Our ref: SL/2023/122661/07-L01
Your ref: EN010128

Date: 25 March 2025

**Application by Cory Environmental Holdings Limited for an Order Granting
Development Consent for the Cory Decarbonisation Project Ref: EN010128**

**The Examining Authority's further written questions and requests for
information (ExQ2) Issued on 11 March 2025**

Figure 1-5: Scenario 4 (Proposed Scheme without Belvedere Power Station Jetty (Disused)) Model Bathymetry

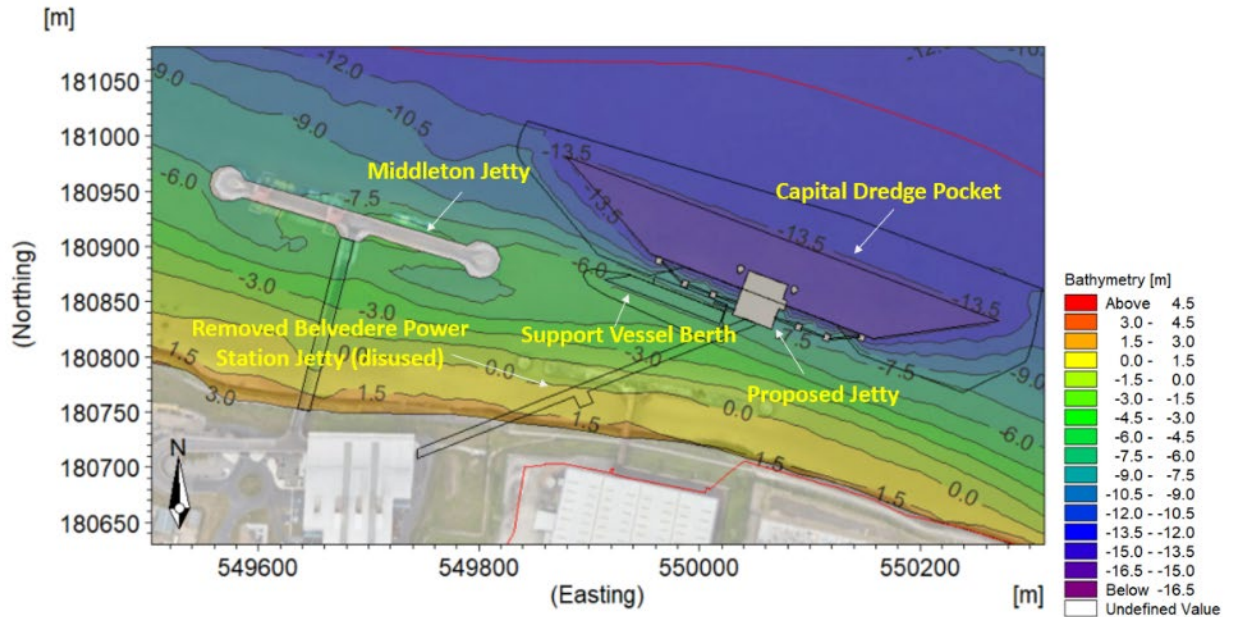
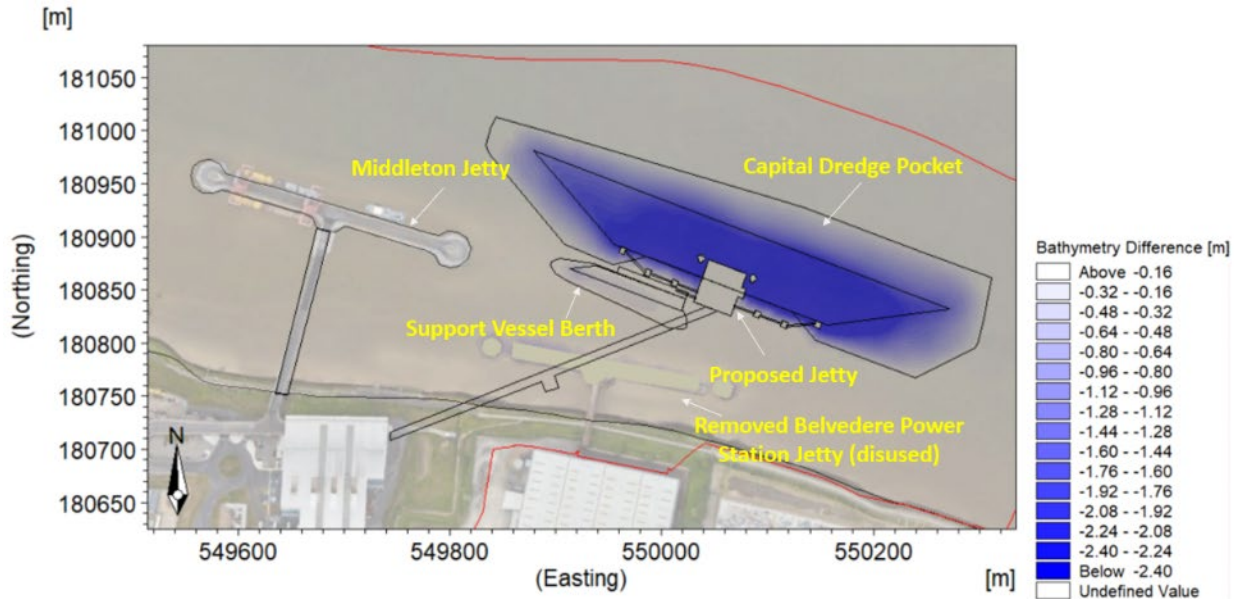
In our opinion the removal of the Old Power Station Jetty should be undertaken as to mitigate for the impacts of the new in-channel works.
